I am emailing in response to the safe distances query from large solar farms. Your email went to my husbands email for some reason so I have emailed from mine now. We are not opposed to solar but opposed to their positioning and the impact of visual impact and noise on residential properties in Knapthorpe. Thus requesting buffer zones be made larger. There are a number of references siting safer distances such as:

I would like to raise two objections to 'X', after looking to the National Policy statements (EN-1 and EN-3).

Cumulative Impact - Averham Park and Knapthorpe Area

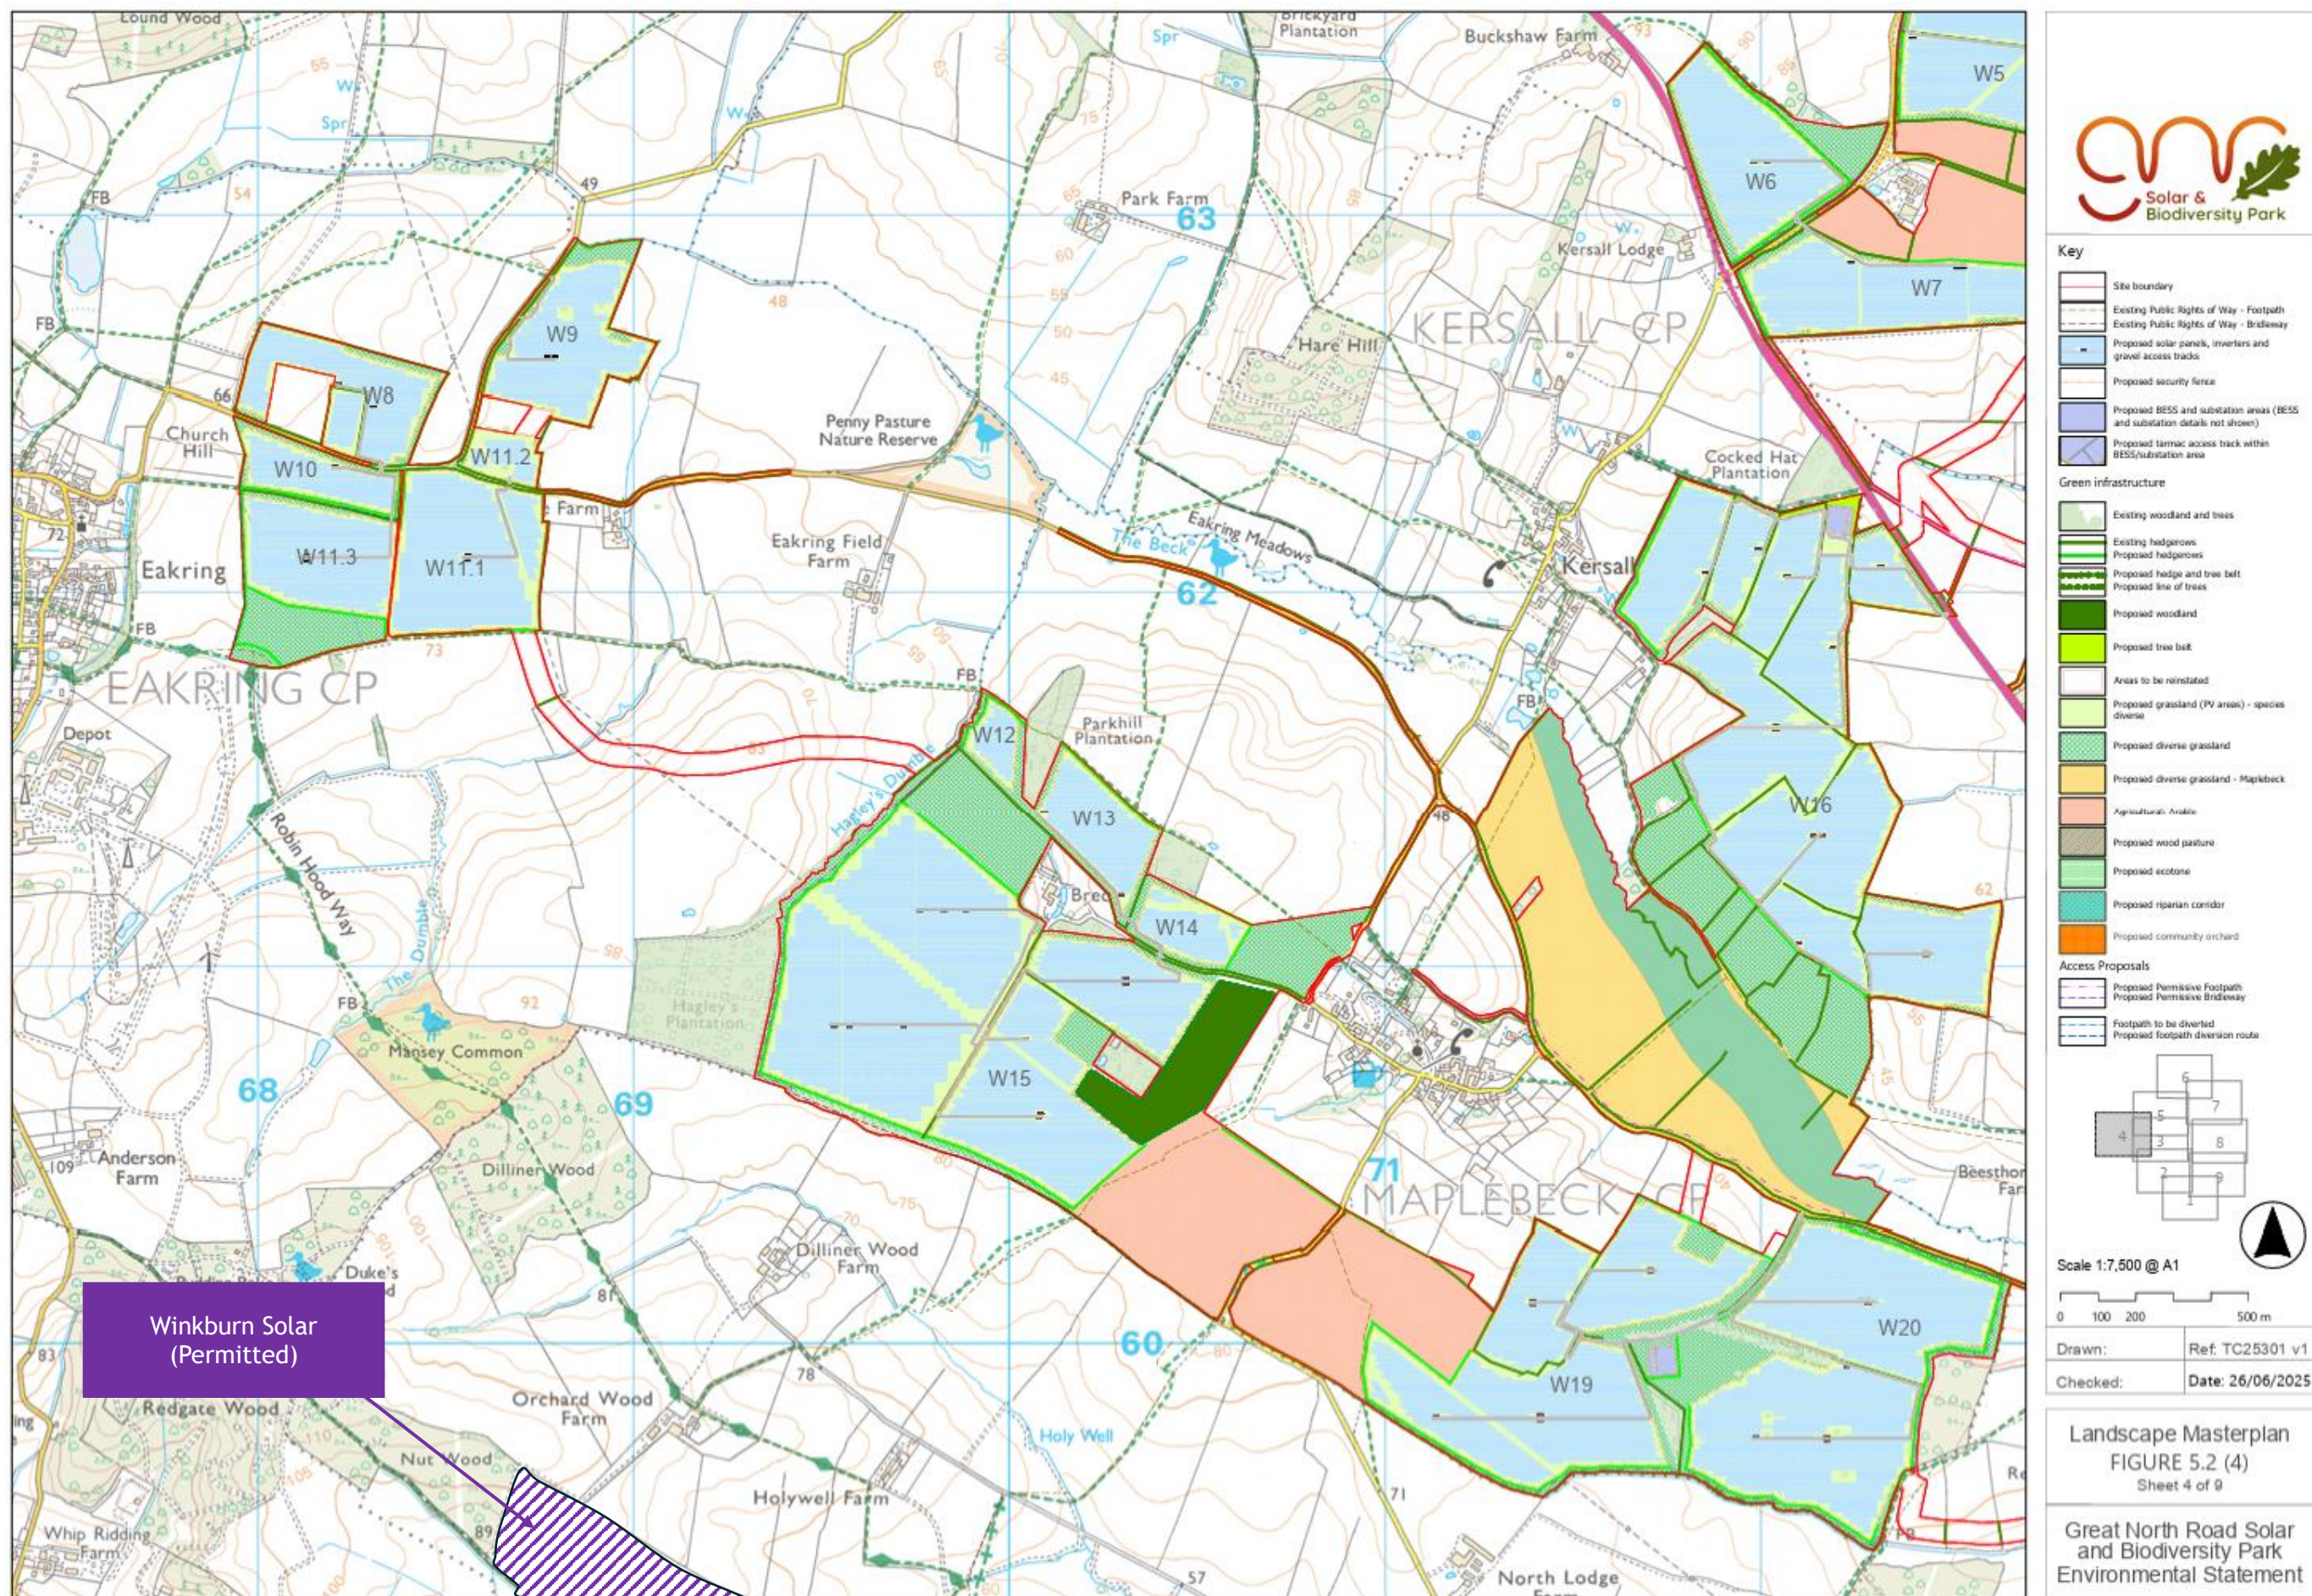
- Please see attached your cumulative assessment plot for the hamlet of Knapthorpe and the circle where our property is. We are being visually enclosed (the large GNR solar park and SSE solar farms are visually overbearing projects). The close proximity of these solar farms combined "cumulative impact" will create a sense of visual enclosure, and this will make us feel hemmed in by industrial infrastructure.

- We are asking for a condition in the DCO which mandates a larger buffer for panels near residential boundaries sited at Knapthorpe.
